MAJOR DEVELOPMENT PLAN AMENDMENT

**NEW RV STORAGE FOR:
FALCON STORAGE
PART W 1/2 SEC 1, T 13 S, R 65 W, 6th PM
PEYTON, COLORADO**

FILE NUMBER PPR2232

SHEET
SDP1.1

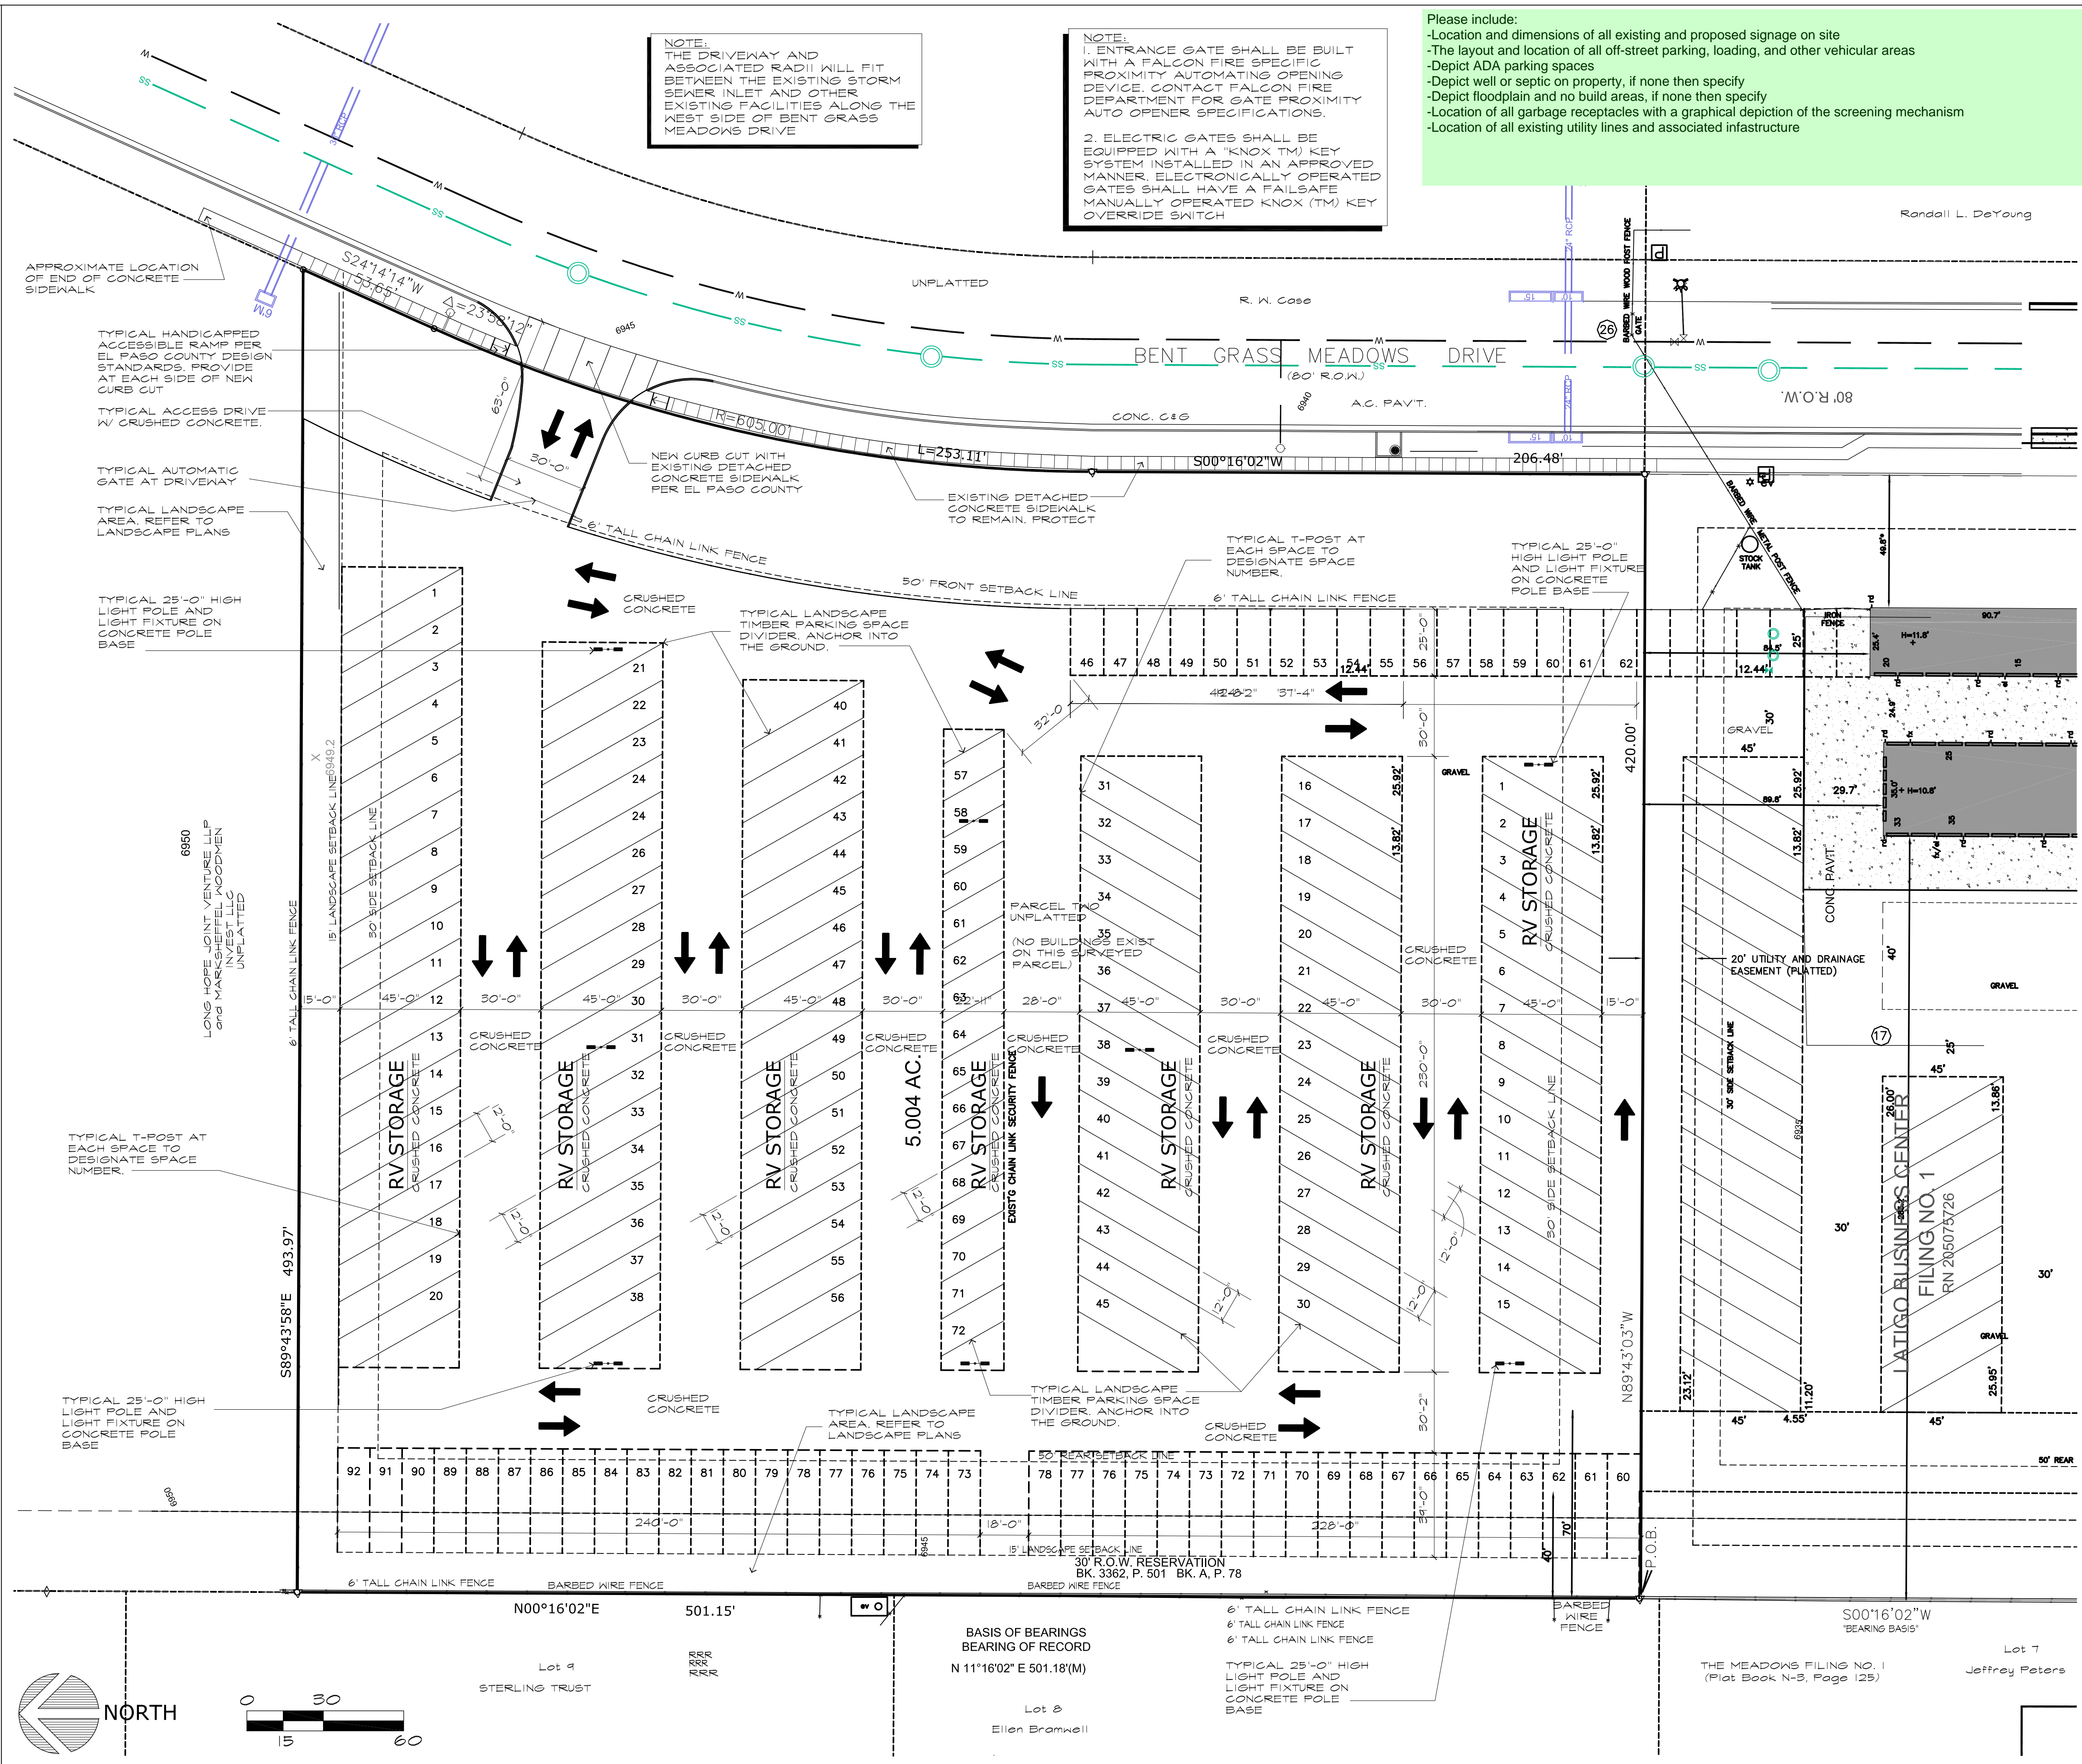
The traffic study indicated that 92 RV spaces are to be added for a total of 310 RV spaces when including the existing lot to the south. Please clarify the discrepancy otherwise provide an updated traffic impact study.

Please remove/revise this note as the driveway is asphalt and an asphalt area is listed below.

if there is asphalt then that would be considered an impermeable surface, please provide that % on front page
